Variation of conditions imposed under CM/1/19/PL relating to conditions 2-plans condition relating to external appearance & 3-amendment of wording to remove reference to acoustic metal cladding to south elevation.

Rudford Industrial Estate, Unit J1, J2 & Z Ford Road Ford

Thank you for your internet comments made on 15th May 2019 which has been recorded as **'an objection'** with the comments as follows:

1 SOUTH ELEVATION
SCALE 1:100 @ A1

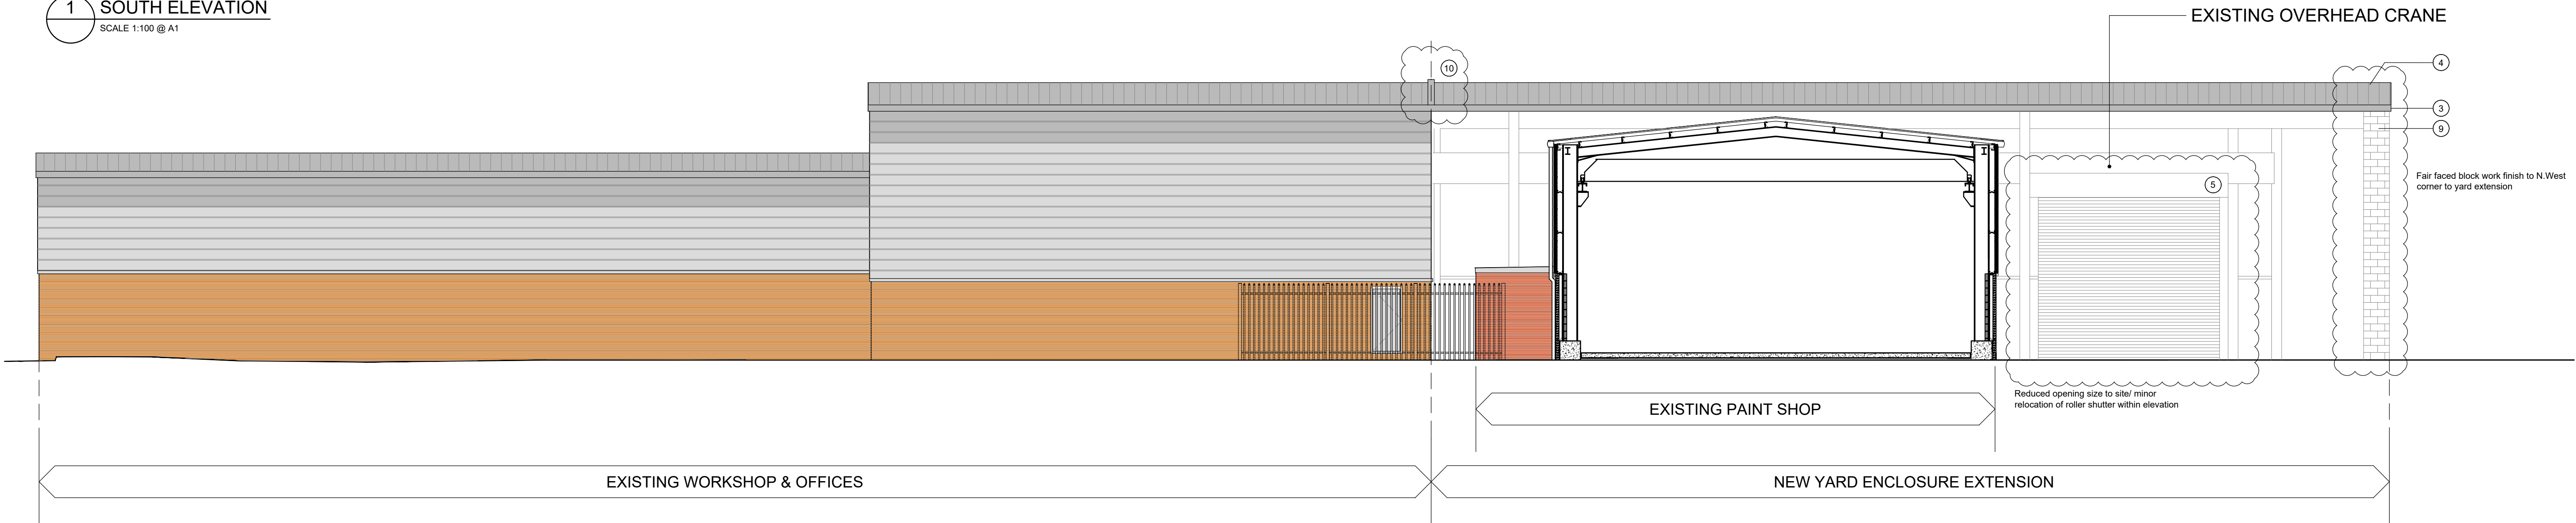
Council objects to the proposal to remove reference to acoustic metal cladding to south elevation as this would be a retrograde step. The condition was imposed to reduce noise pollution and should be retained.
